## Fire Marshal Division

**RE: Alejandro's Subs**  
**3039 Buffalo Lakes Rd.**  
**Sanford, NC 27332**

**Re: Application Number – FMFW2102-0005**

PROJECT NAME & ADDRESS:
Alejandro's Subs and Grill

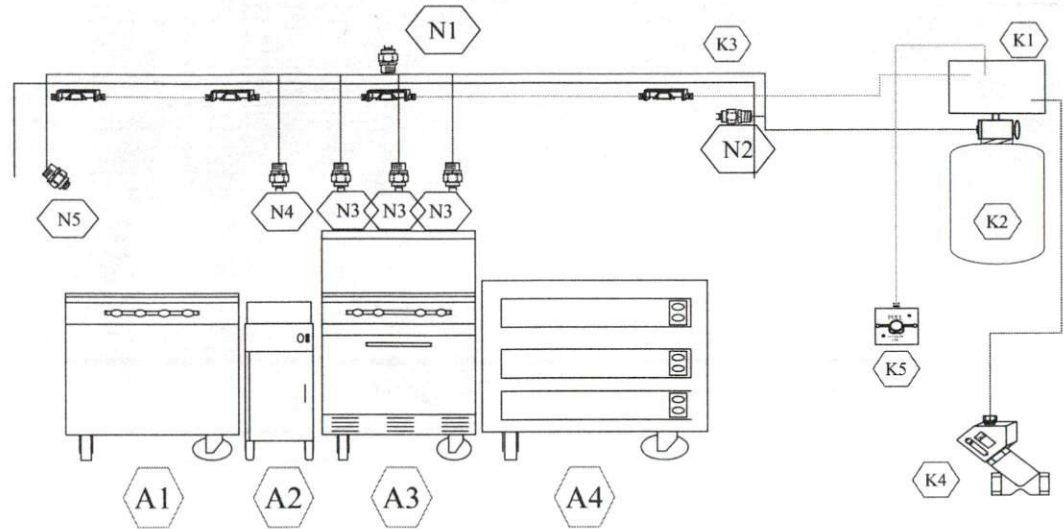
- **Commercial cooking equipment.**
  - A multi-purpose ABC type extinguisher (minimum 2A-10BC) shall be provided and mounted within 5ft. of the finished floor with a maximum travel distance of 75 ft.
  - Portable fire extinguishers shall be provided within a 30-foot (9144 mm) travel distance of commercial-type cooking equipment. Cooking equipment involving vegetable or animal oils and fats shall be protected by a Class K rated portable extinguisher.

- **Manual system operation**
  - A manual actuation device shall be located at or near a means of egress from the cooking area, a minimum of 10 feet (3048 mm) and a maximum of 20 feet (6096 mm) from the kitchen exhaust system. The manual actuation device shall be located a minimum of 4.5 feet (1372 mm) and a maximum of 5 feet (1524 mm) above the floor. The manual actuation shall require a maximum force of 40 pounds (178 N) and a maximum movement of 14 inches (356 mm) to actuate the fire suppression system.

- **System Interconnection**
  - The actuation of the fire suppression system shall automatically shut down the fuel or electrical power supply to the cooking equipment. The fuel and electrical supply reset shall be manual.

- **Monitoring**
  - Where a building fire alarm system is installed, automatic fire-extinguishing systems shall be monitored by the building fire alarm system in accordance with NFPA 72.
